From: Thomas Callaway
Sent: 02 September 2014 16:11
To: Planning.Responses
Subject: RE: Planning Consultation on A/116/14/DOC

APPLICATION NO: A/116/14/DOC

Site Address: Land South of A259 & West of Mill Lane Rustington

Description of Works: Application for approval of details reserved by conditions 3, 4, 5, 6, 7 (Full) and 17, 18, 19, 20 (Outline) imposed under Hybrid Application Approval A/125/13 relating to water maintenance, foul and surface water disposal and management of SUD's.

Section 278(11.1) Works

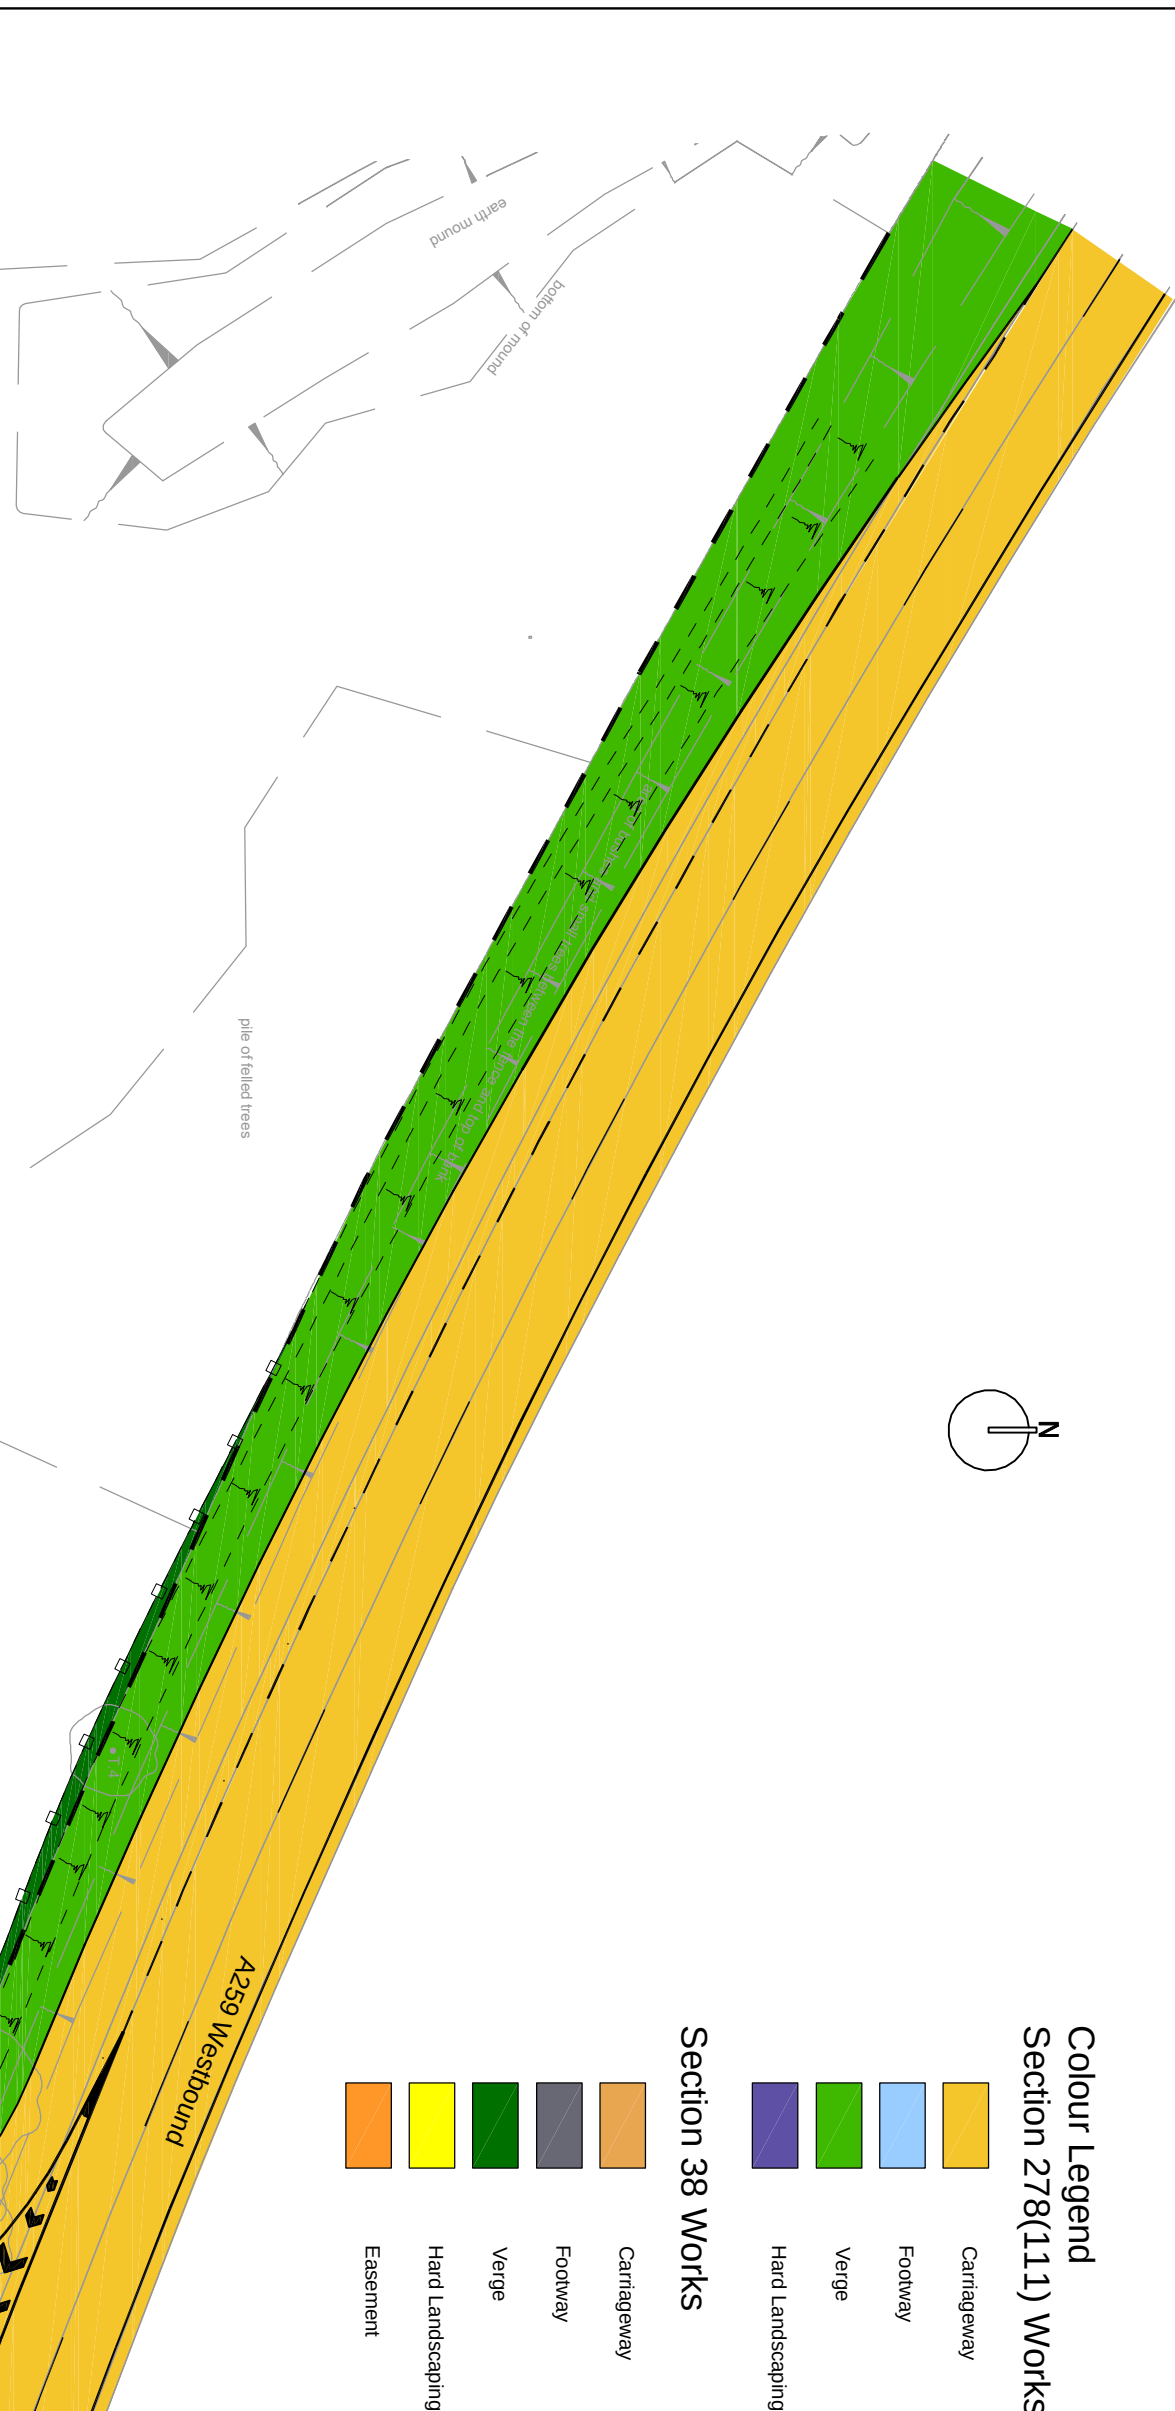
Please consult West Sussex County Council regarding surface water drainage of the access road section in the middle of the site (s278/38 works). They may suggest some improvements and require confirmation of how the restricted flow rate is calculated and achieved.
